CITY OF ALBUQUERQUE

**Re: Martinez Hair Salon, 5801 Central Ave. NW,
 Permanent Certificate of Occupancy
 Engineer's Stamp dated 10-20-05 (K-11/D074)
 Certification dated 6-04-07**

Re: Martinez Hair Salon (K-11/D074)
119 58th St NW
Permanent Certificate of Occupancy
Certification dated 4/23/07

TRAFFIC CIRCULATION LAYOUT APPROVED

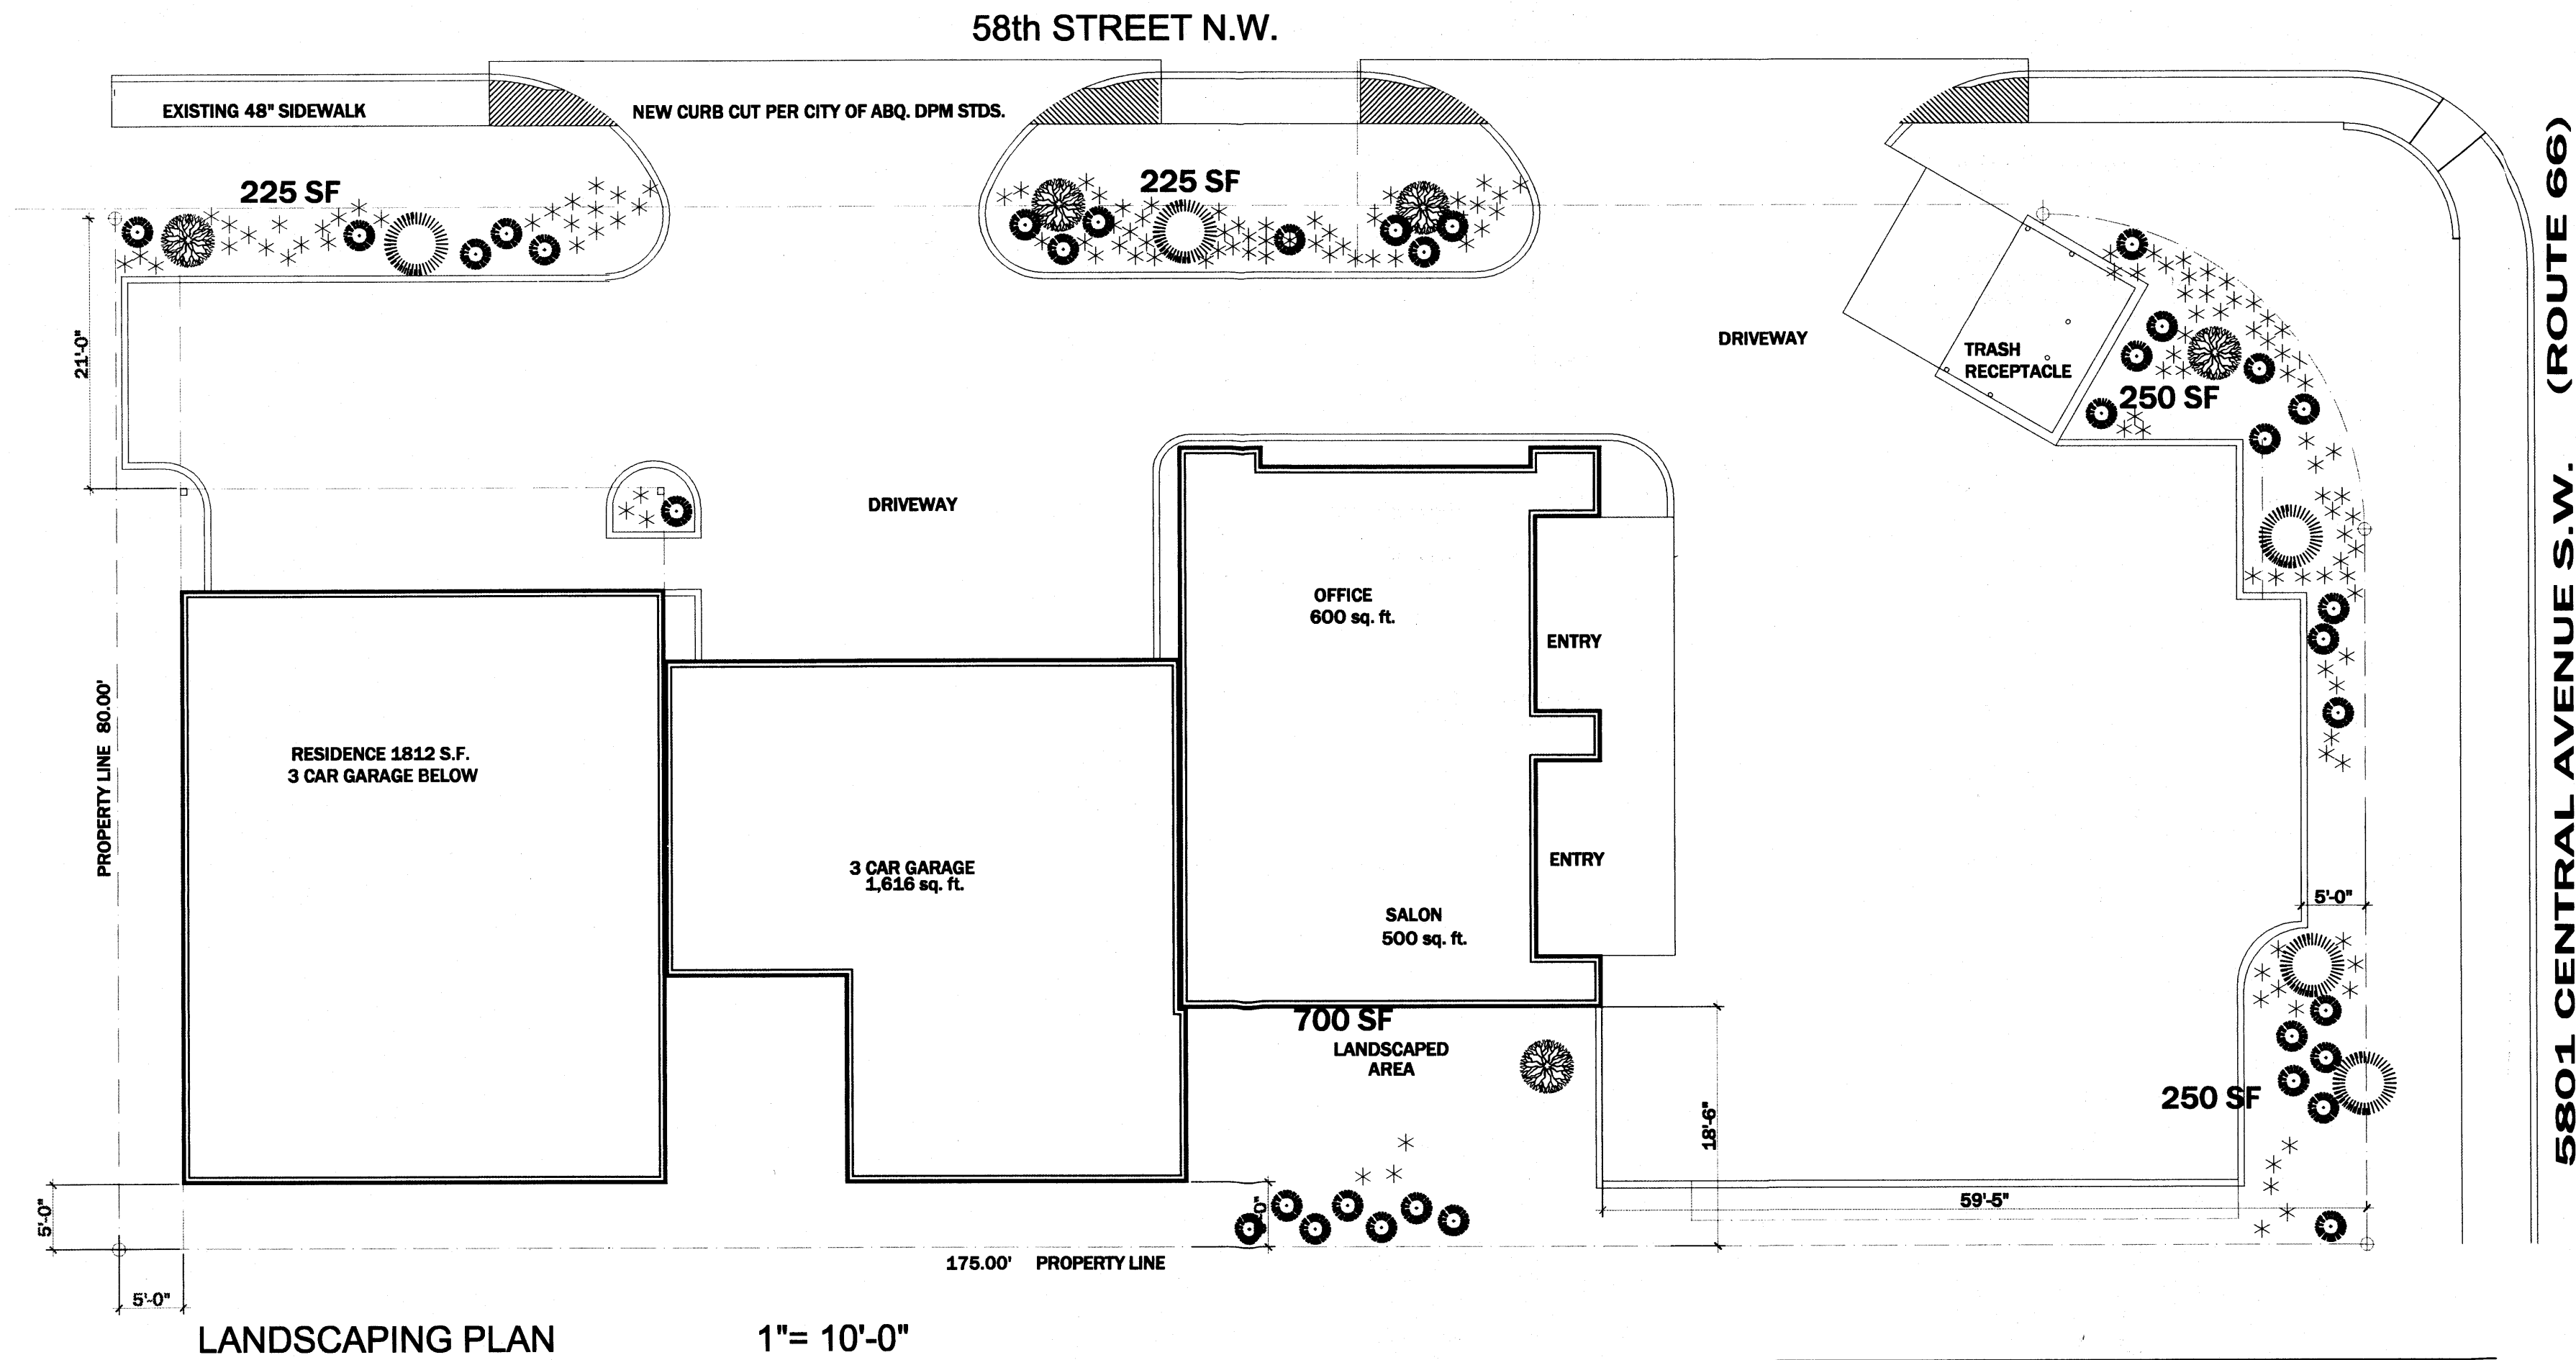
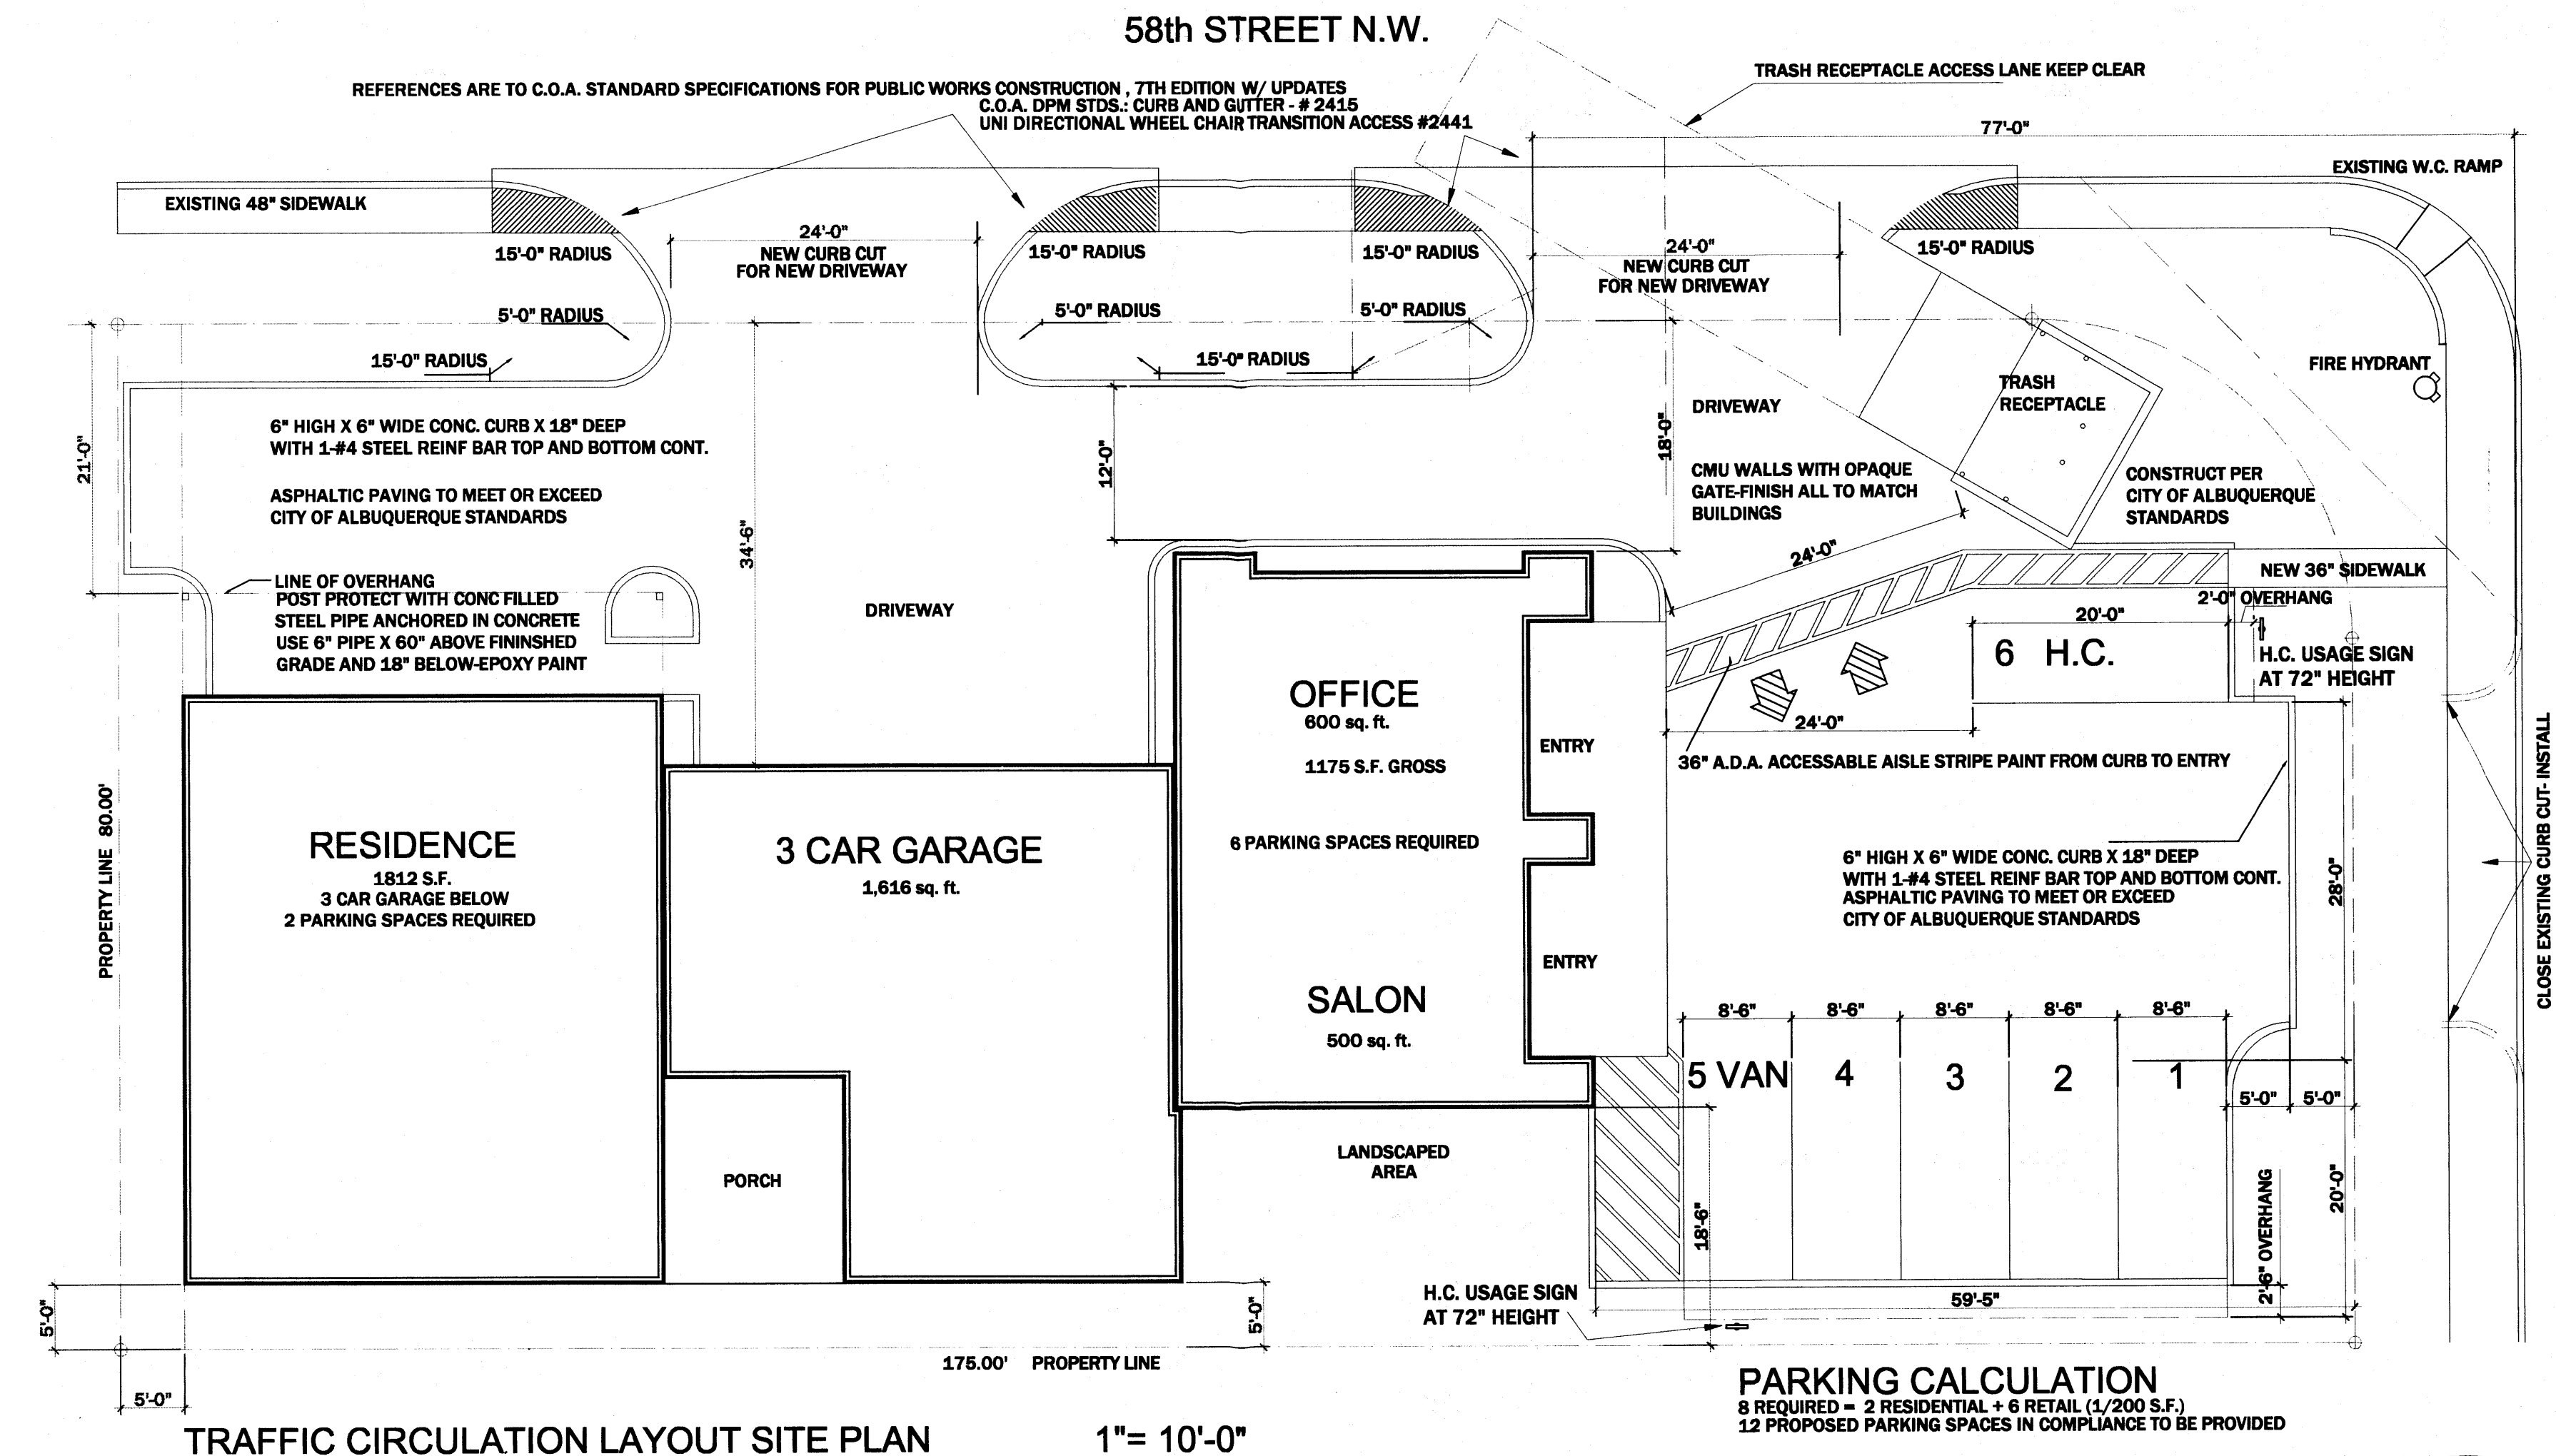
A Temporary C.O. has been issued allowing the outstanding **driveway closure (fronting Central needs to be closed)** and **sidewalk connection (the deleted connection from Central onto Site needs to added per approved TCL Site Plan)** issues to be completed within this time period. When these remaining issues have been fully completed, are in substantial compliance, and a final Certification for Transportation has been resubmitted to the City's Hydrology office for approval, a Permanent C.O. will be issued.

- Submit a Traffic Circulation Layout Plan not a Grading and Drainage Plan.
- Provide parking calculations designating the number of parking spaces required by zoning as well as the number of parking spaces proposed.
- Correct Note #1 to reference the C.O.A. Standard Specifications for Public Works Construction, 7th Edition w/ updates.
- Provide build notes for both curb cut locations and reference C.O.A. Standard Drawing number.
- Provide a minimum of 15' radii at driveways.
- Provide a minimum of 24' aisle width between refuse screen wall and office/salon curbing.
- Call out typical length of parking stalls. The minimum length is 20'.
- Call out the ADA aisle width. The minimum width for van accessible parking is 8.5'.
- Submit two copies of the Traffic Circulation Layout Plan.
